18 December 2023

Section 73 Planning Application: Alterations and extensions, new buildings and landscaping scheme (variation of condition 2 of Planning Permission 22/00767/HHD to allow minor changes to the approved scheme).

Listed Building Consent Application: Internal and external alterations comprising demolition works, extensions, new buildings and landscaping scheme (amendments to 22/0779/LBC).

Wootton Place, Church Street, Wootton, Woodstock, OX20 1EA

Drawing Title  
**Proposed Details**

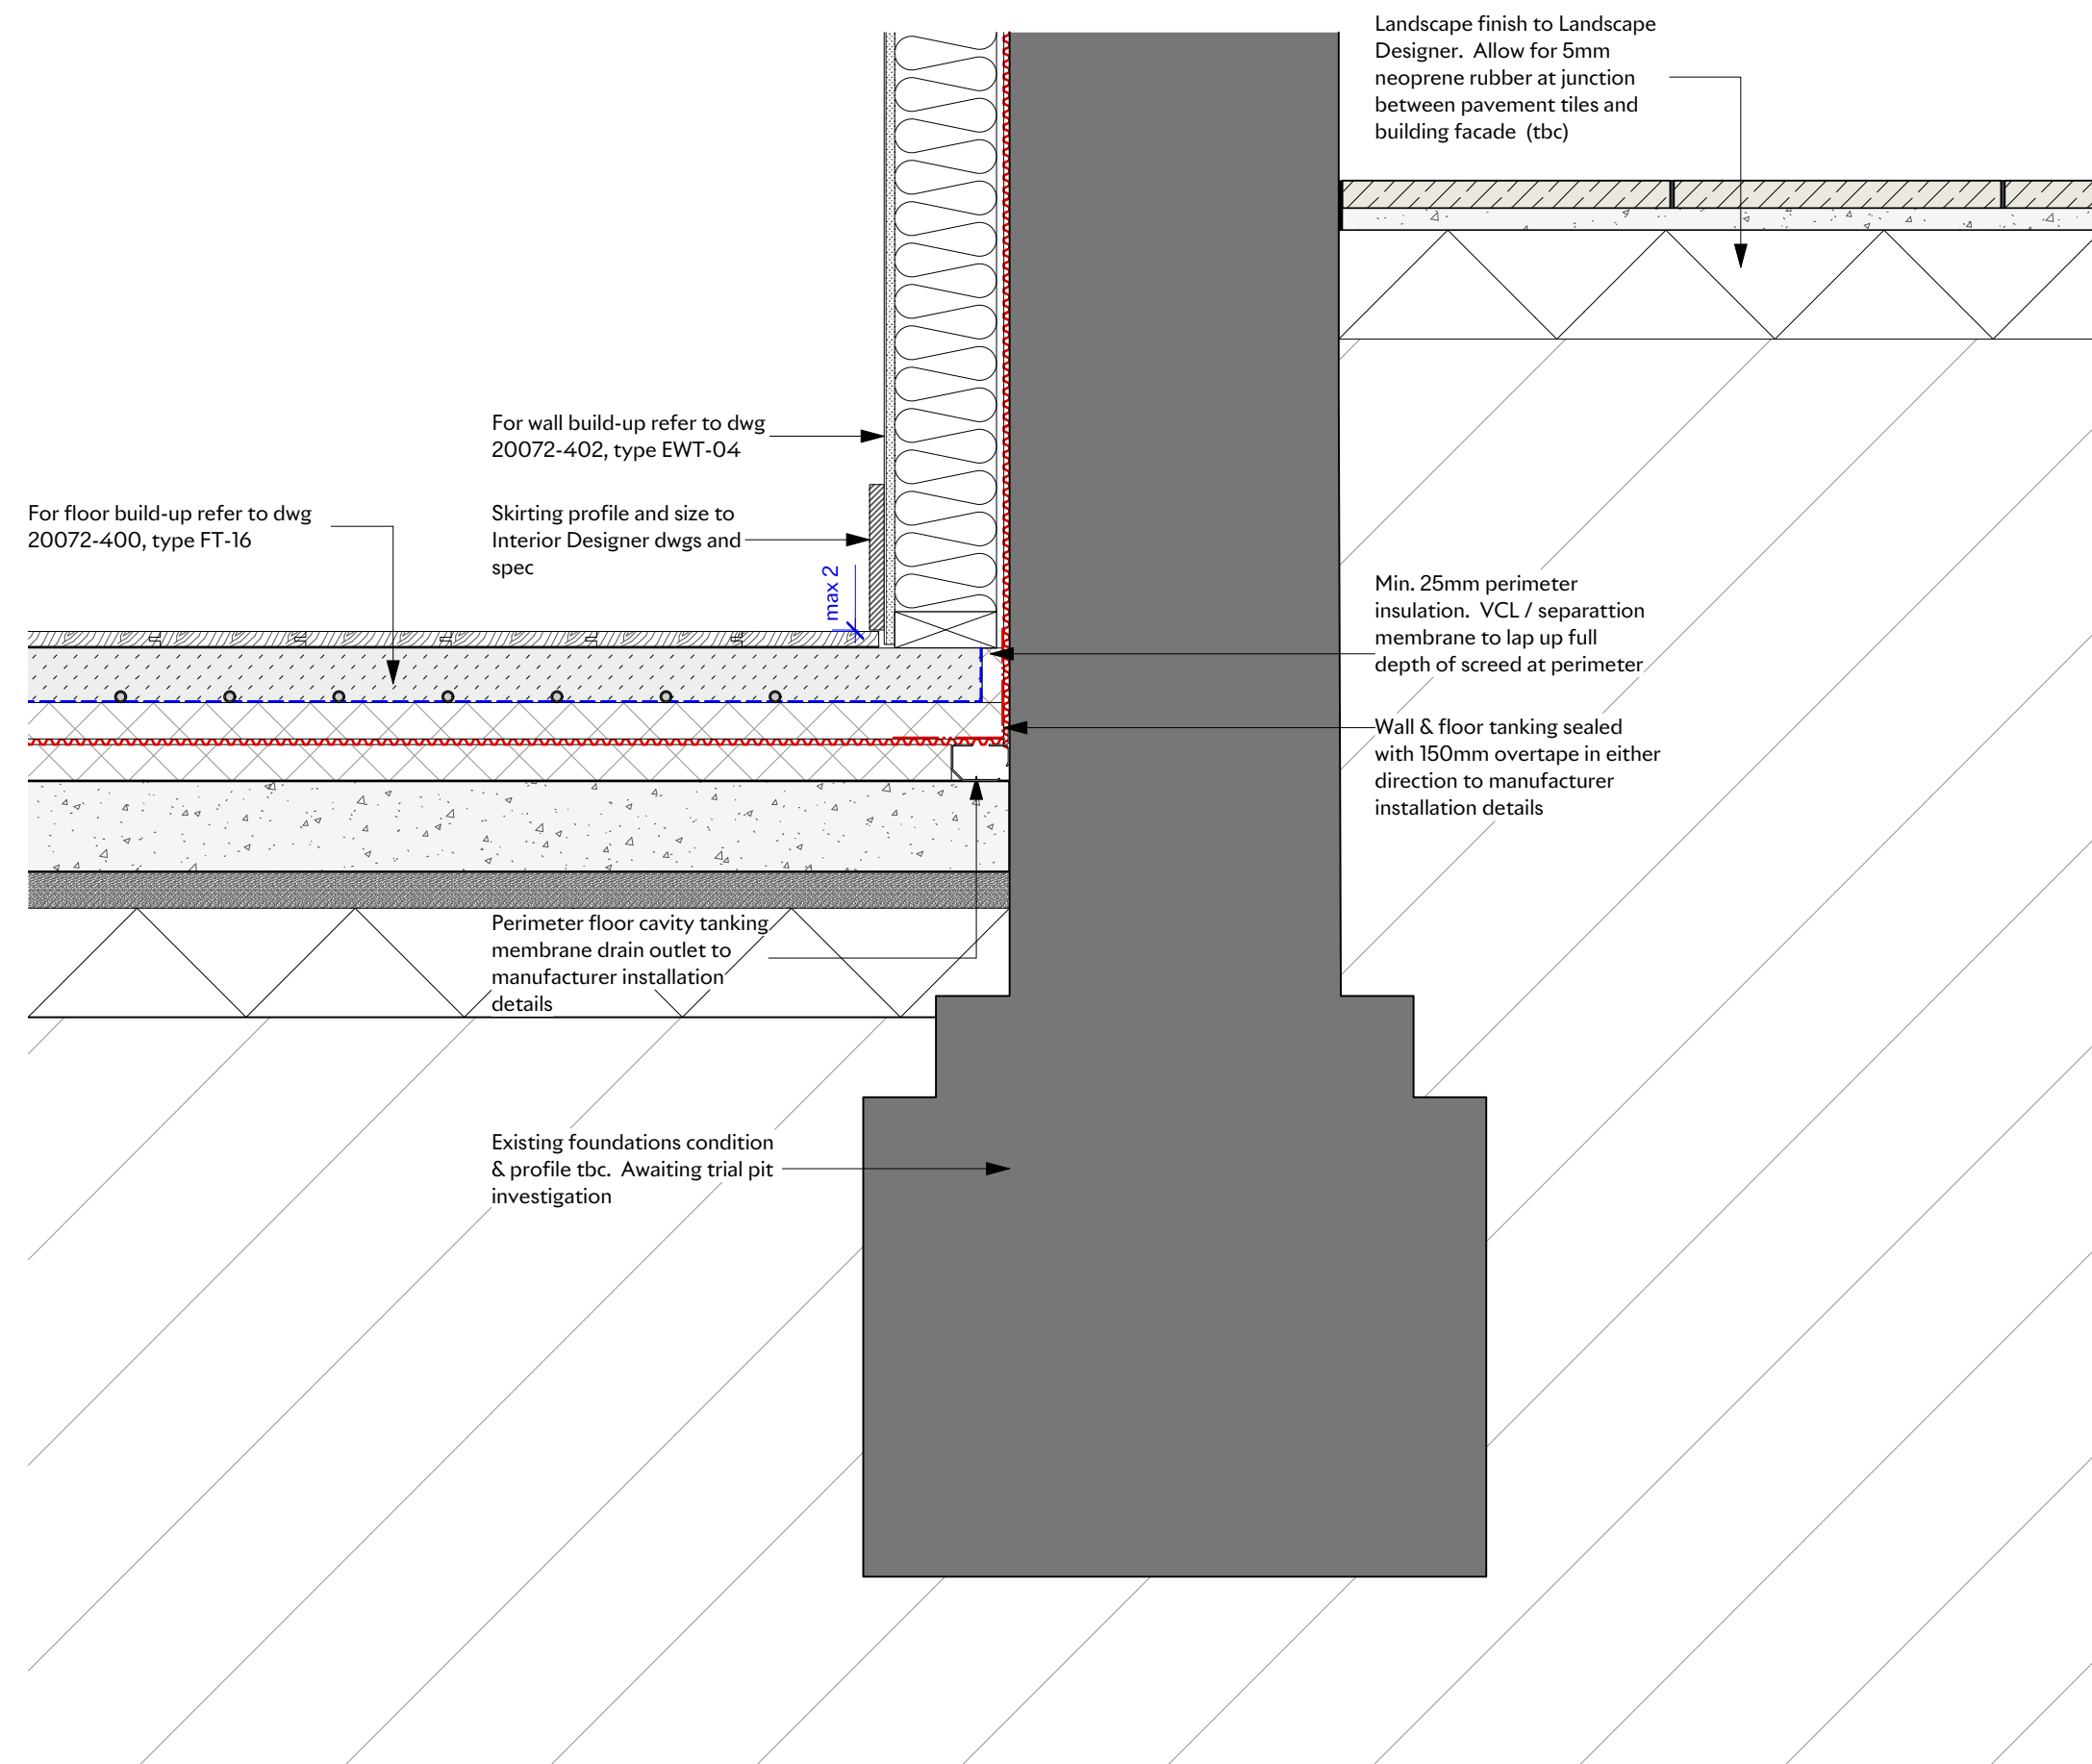
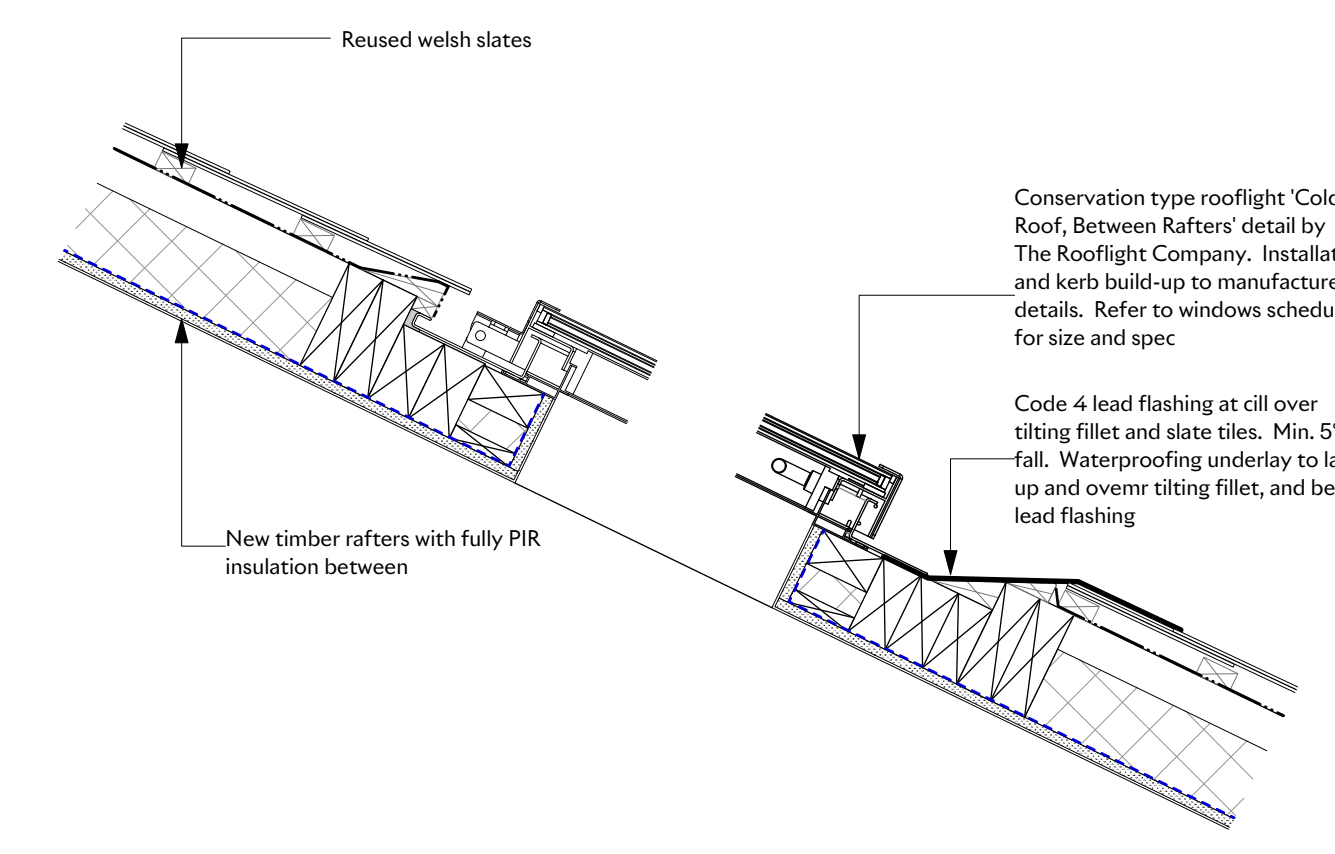
- *Internal lining of stable walls to provide insulation to the spaces.*
- *Removal of existing ground bearing slabs and addition of new insulated ground bearing slabs.*
- *Minor alteration of the internal slab level to the existing library.*
- *Addition of a new pair of doors to the east elevation of the stables.*
- *Minor reconfiguring of rooms at FF and SF level.*
- *New opening in wall to Rose Bedroom and the previous en-suite to the guest bed.*
- *Reinstatement of the bedroom above the library.*
- *Levelling of floor joists to the guest bed with the hallway, and in turn raising the ceiling height of the Boot Room (we believe this work will take it back to its historic level).*
- *Replacement of roof structure serving library, study and art studio.*
- *Insertion of metal conservation style rooflights in the new roof.*

**Proposed Pool House Elevations & Section**

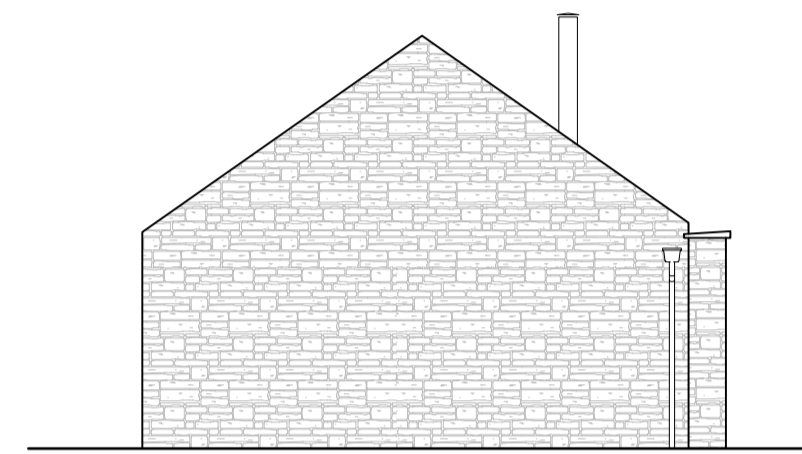
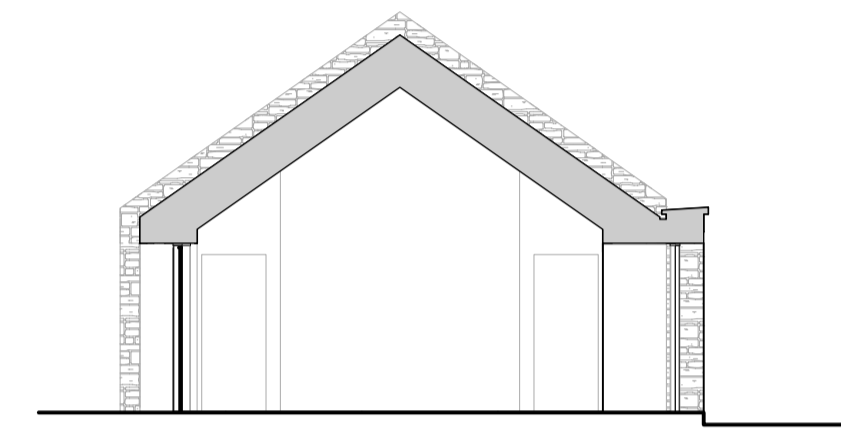
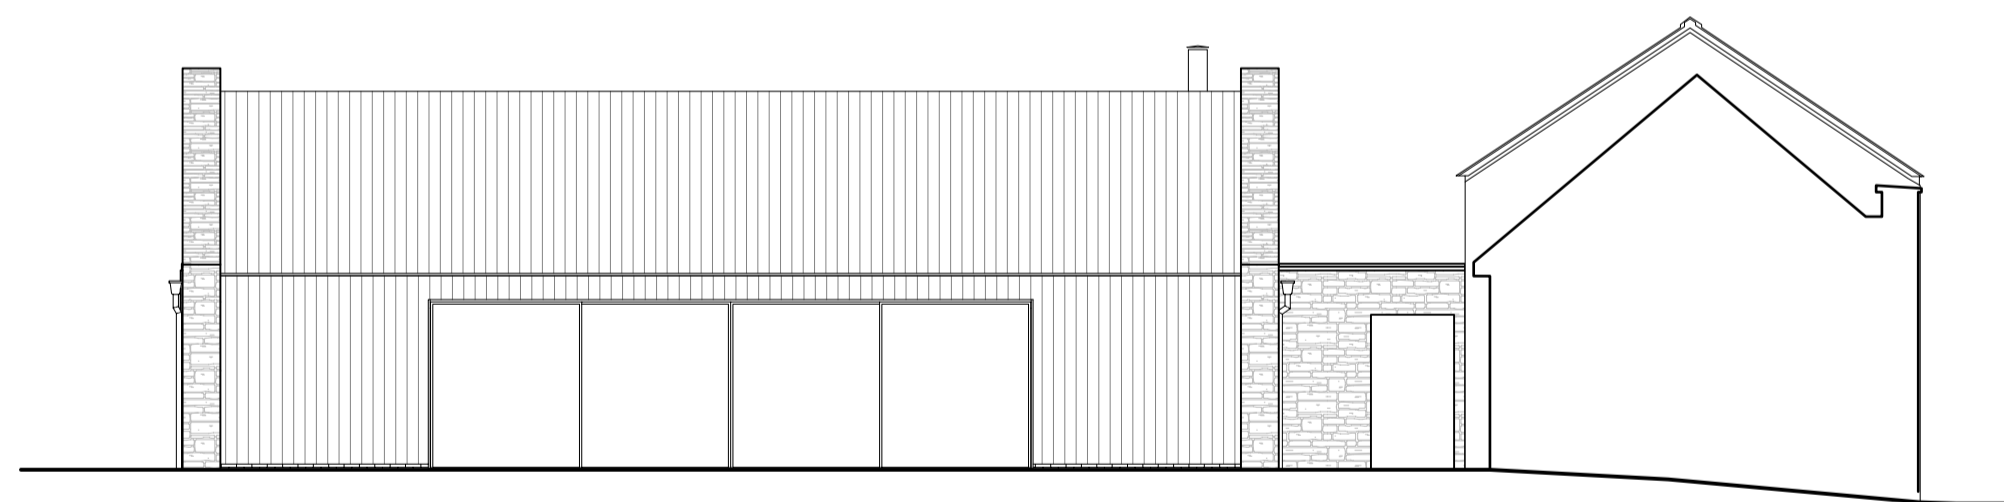
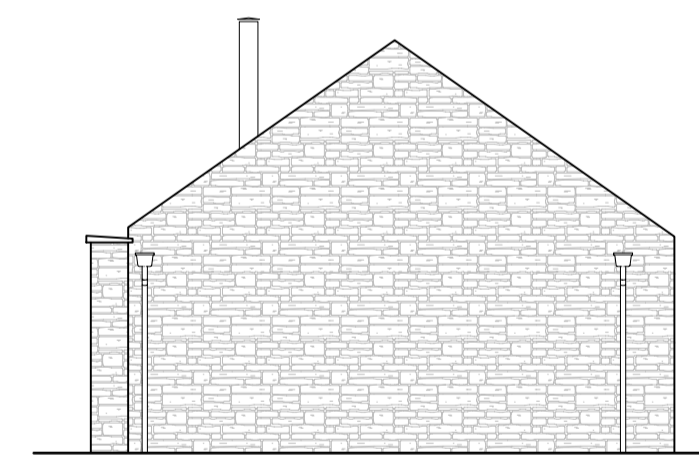
- *Increase in depth and width of Pool house and reconfiguration of internal spaces.*
